Honeycutt Hills Community

Lot 02 – Stonefield 1 Model

AS-BUILT CONDITIONS

M+K Project #: 126-23047 (40/04)

sheet:
S2.0

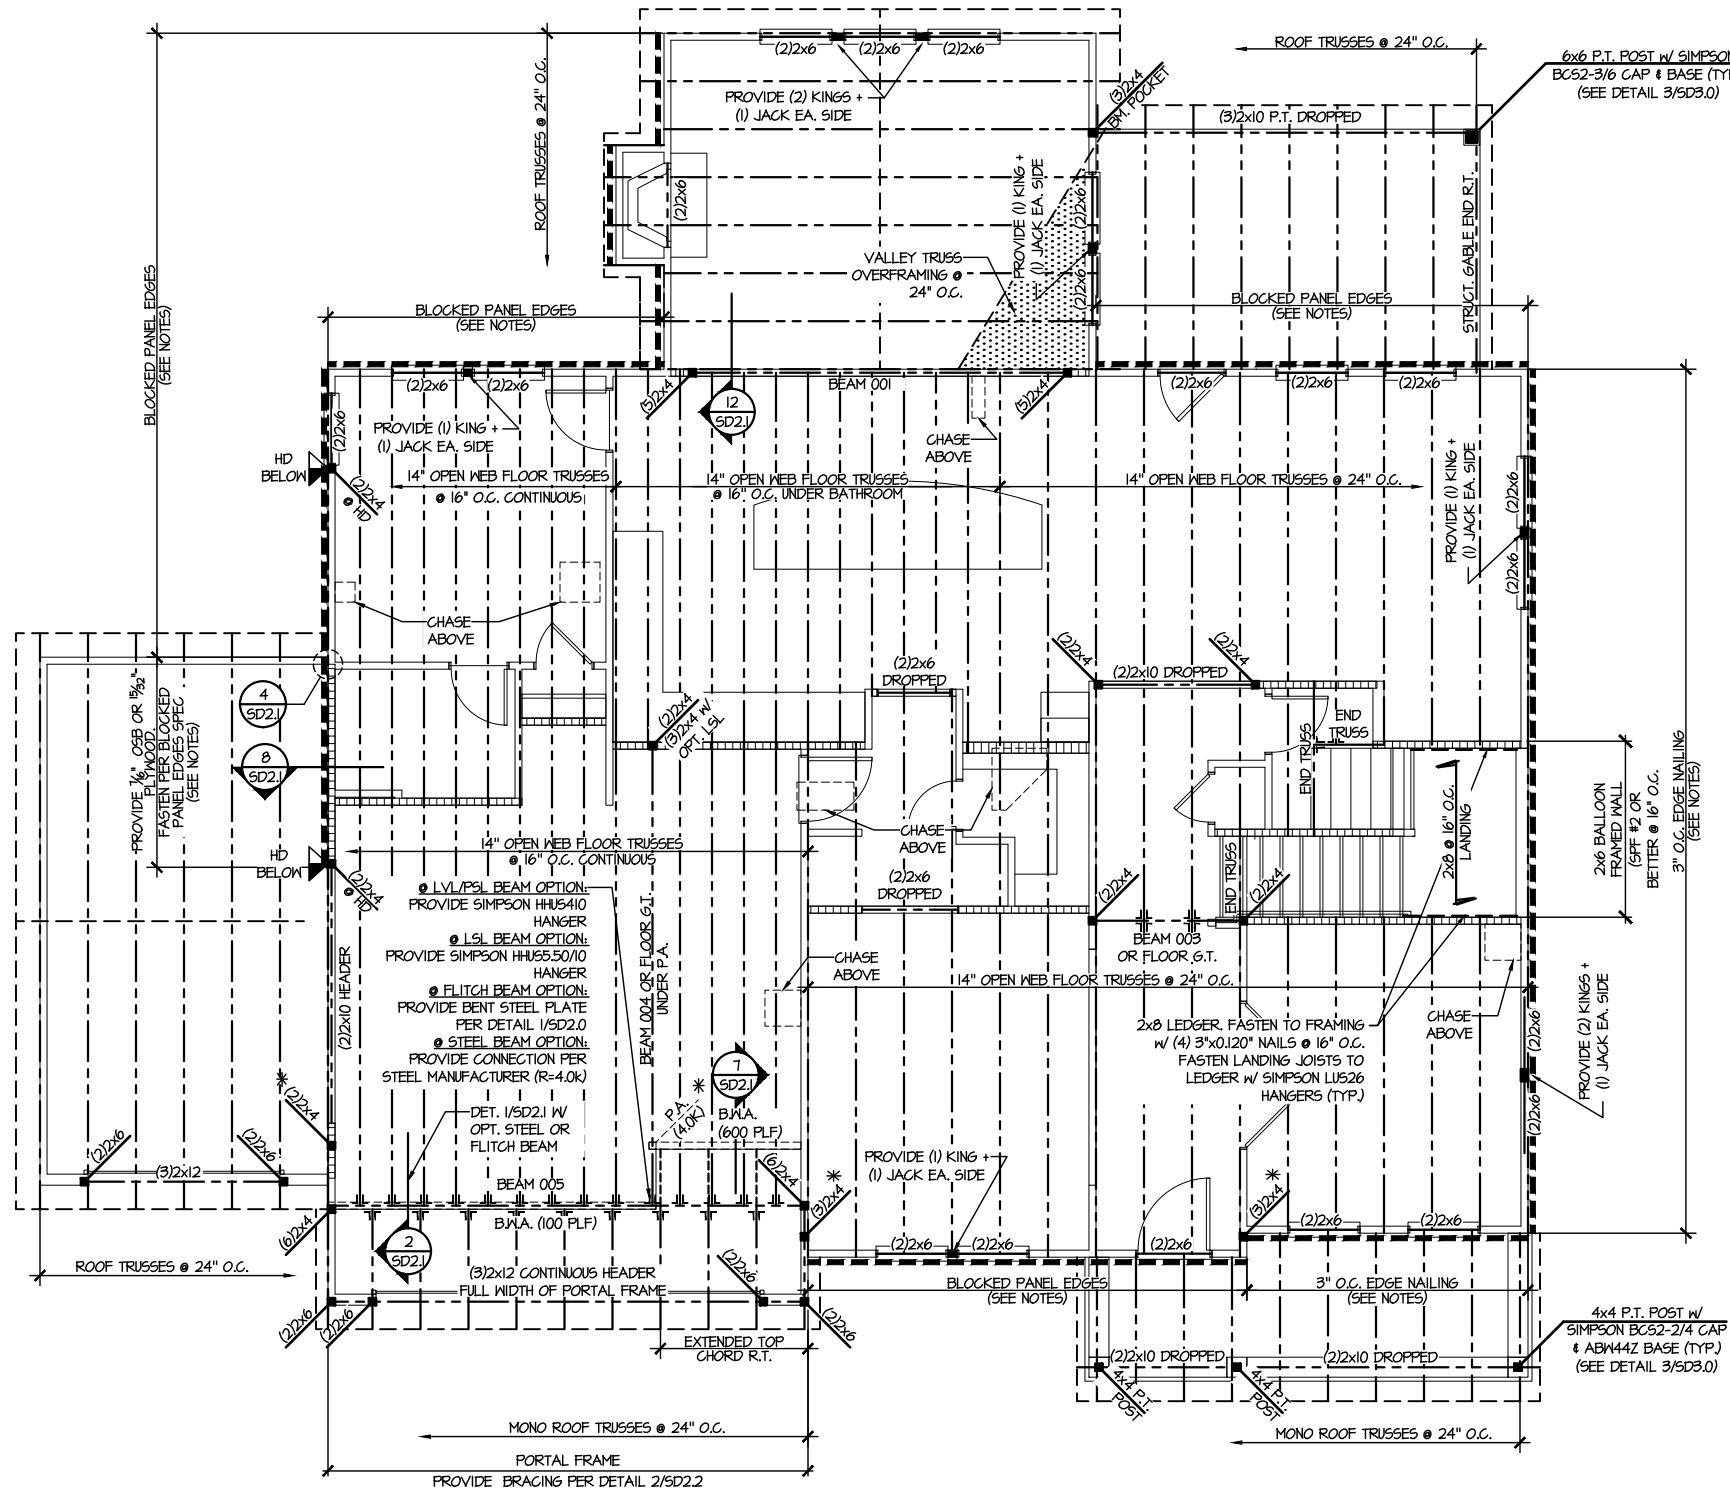
- It was reported to us, by you, that the rear covered porch (3)2x10 beam was cut short and thus cannot be pocketed into the wall to bear on the beam pocket shown on the structural plans.

- It was reported to us, by you, that the stair landing was not framed per the structural plans. The structural plans call for 2x8 landing joists fastened to a 2x8 ledger with Simpson LUS26 hangers. Instead, the landing joists were pocketed into the bearing wall. It is our understanding that each 2x8 landing joist has full bearing on a 2x4 bearing wall stud at both ends, directly adjacent to a full height 2x4 bearing wall stud..

We have analyzed this condition, and it is our professional opinion that a (5)2x4 post must be added within the wall at the beam location and a Simpson LUS210-3 hanger must be provided and nailed per Simpson nailing specifications into the (3)2x10 beam and into the new post. Any additional waterproofing or house wrap required will be per the architect.

We have analyzed the as-built condition, and it is our professional opinion that this method of framing the stair landing is structurally adequate and no repair is required for this condition. Each 2x8 landing joist should be fastened at each end to the adjacent full height 2x4 bearing wall stud with (2) 3" long x 0.120" diameter nails.
